From: "Ray Doyle" <raydoyle@tpg.com.au>
To: <plan_comment@planning.nsw.gov.au>
Date: 2/12/2012 10:08 AM
Subject: NWRL EIS 2

Name of application: Robert Road incorrect classification
 Application No: (SSI – 5414)
 I object to Robert Road being classified as a main bus feeder into Cherybrook Railway Station.
 Reason why I reject Robert Road being used as a bus route as follows

Figure 6.12 Cherrybrook Station - Indicative vehicle and pedestrian movements

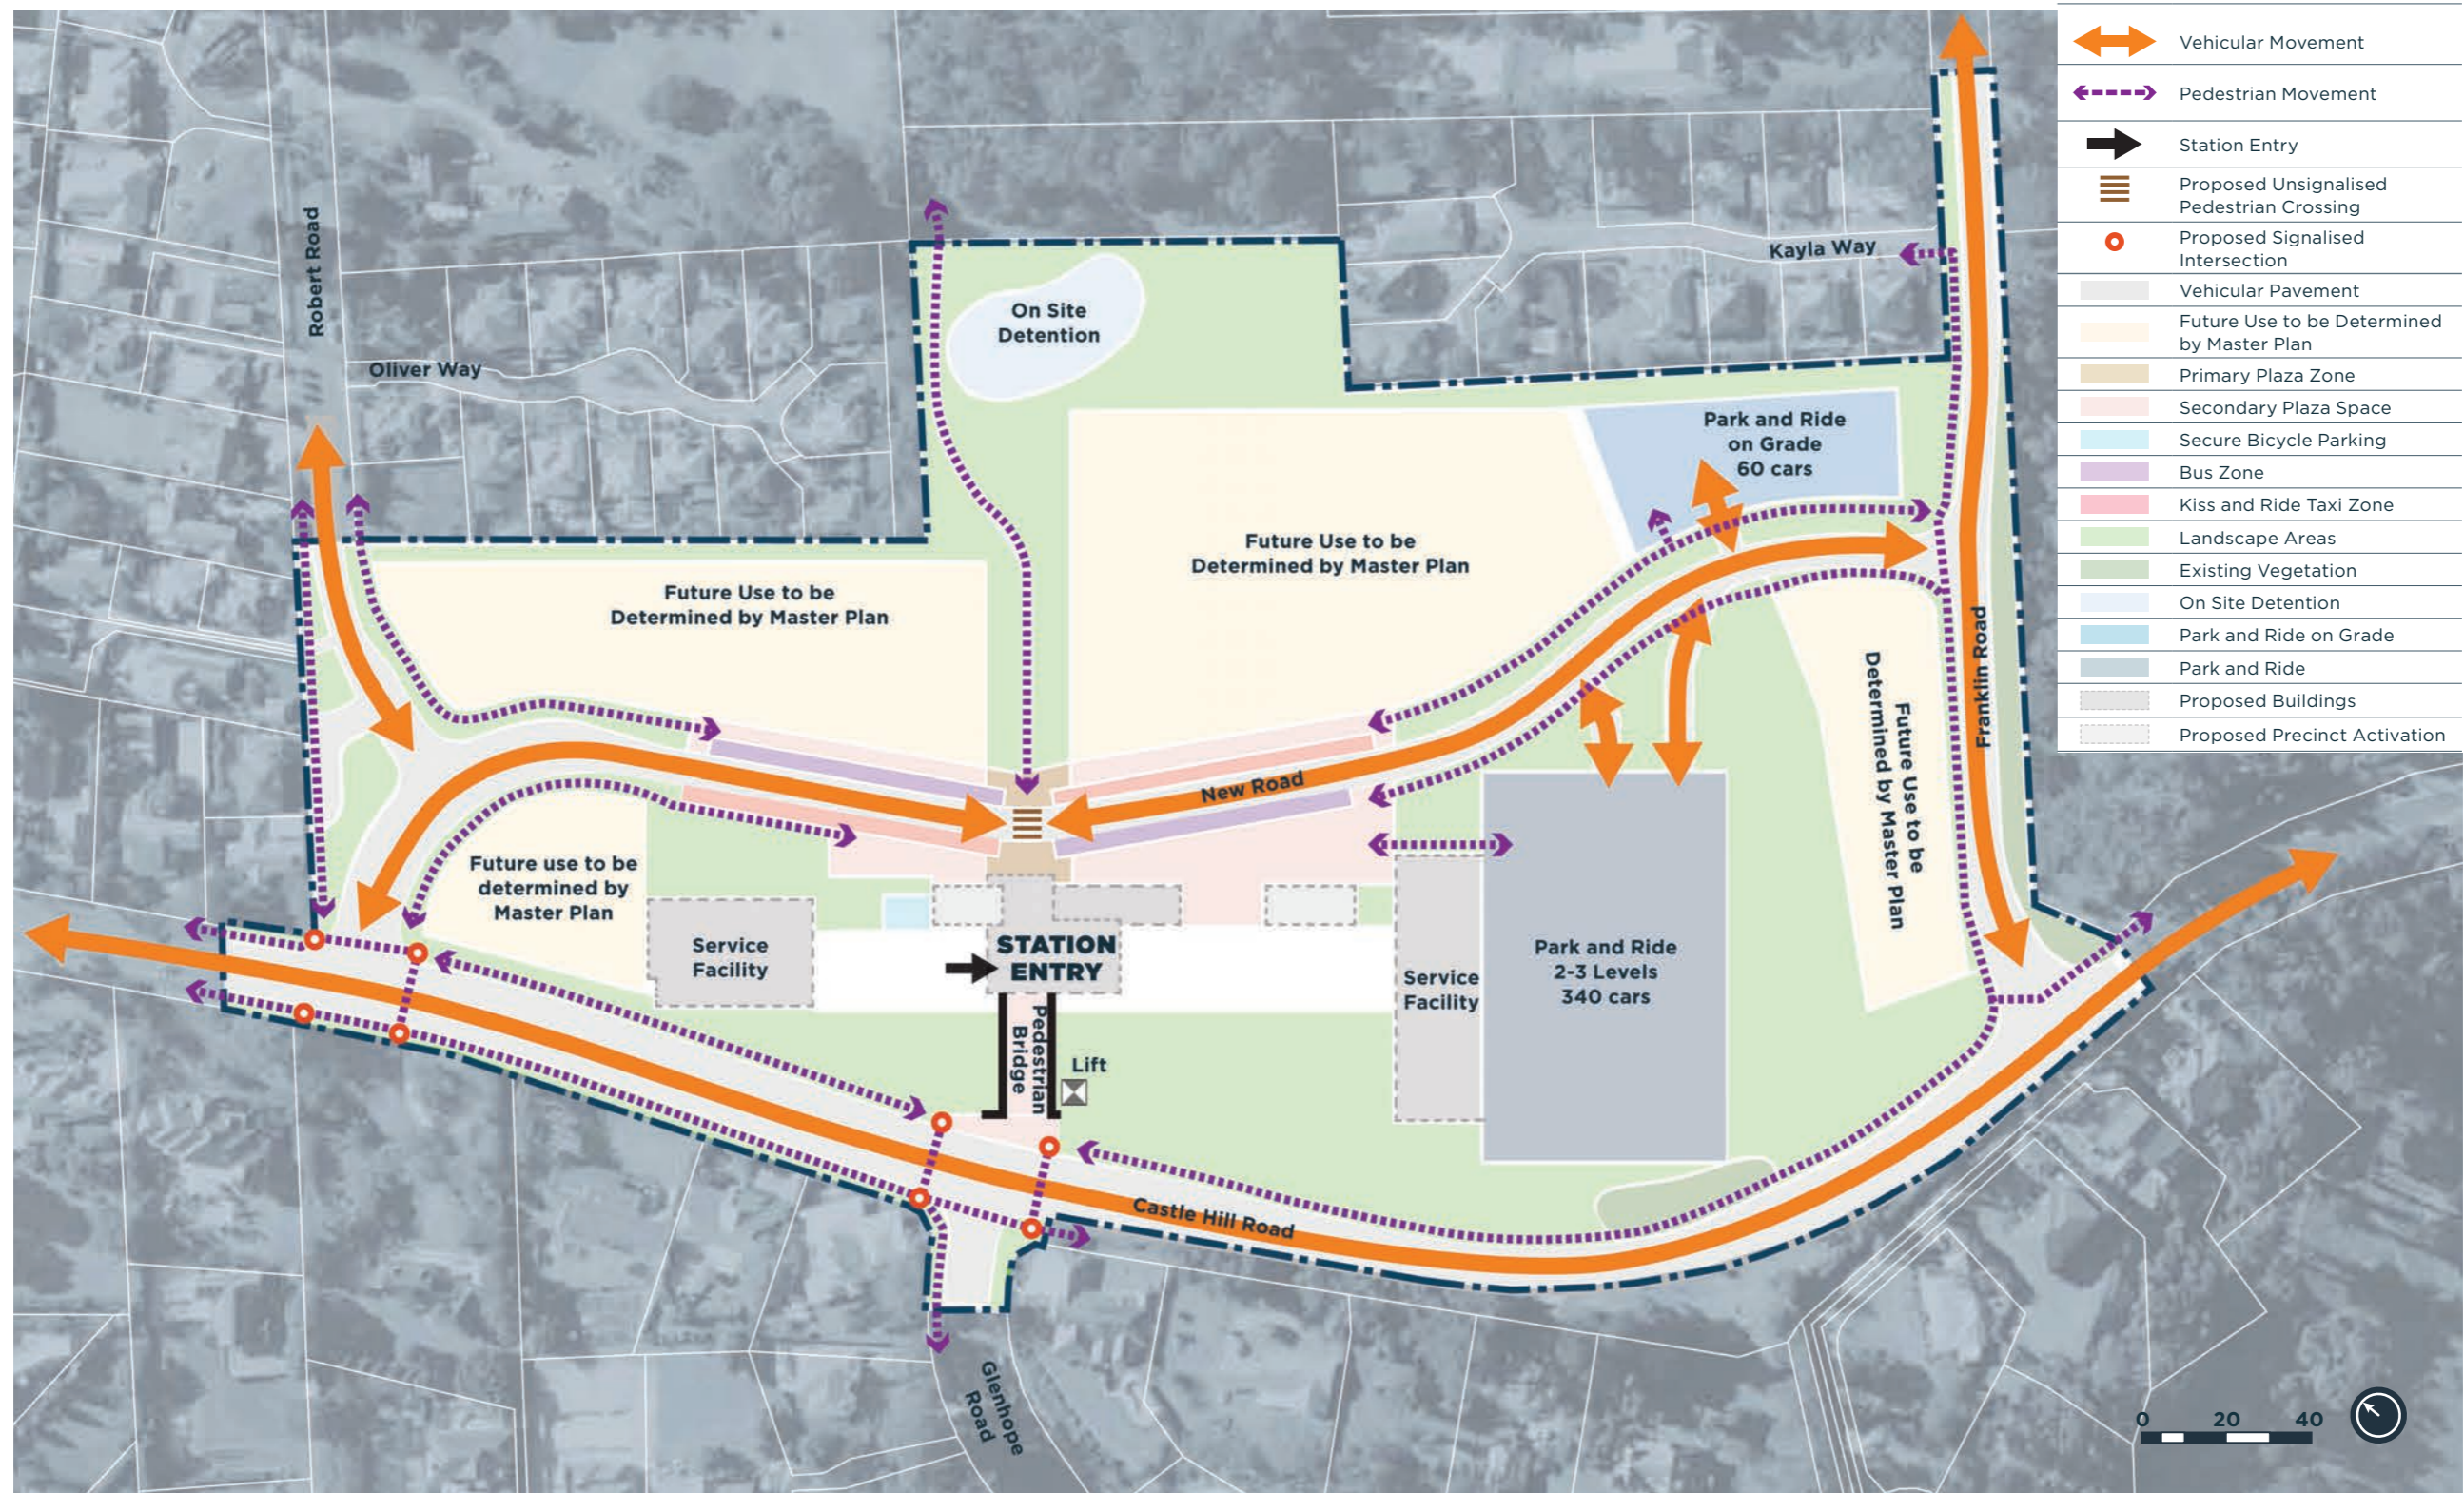
MY RESPONSE: This is Totally Incorrect. The actual road width of Robert Road is 7 m and Franklin Road is close to 9 m (for section between Doulton Drive and Castle Hill Road). IF anyone has access to GOOGLE EARTH, you can measure the width (there is tool).

ALSO NOTED THAT ROBERT ROAD HAS BEEN REFERRED AS LOCAL ROAD BY HORNSBY SHIRE COUNCIL (REFER CHAPTER 9, SECTION 9.5.2) AS PER AUSROAD (National Association of Roads and Traffic Australia which is national body for road standards), Local Road is classified as two way lane with 2 parking lanes allowed and width a carriageway width of 9 m. FRANKLIN road fits into this category of local road, not ROBERT road.

Robert Road (based on 7 m) carriageway width is to be classified as Cul-de-Sac or Access road (it is not very specific), BUT it is not a LOCAL road (as referred by Council) by any standards.
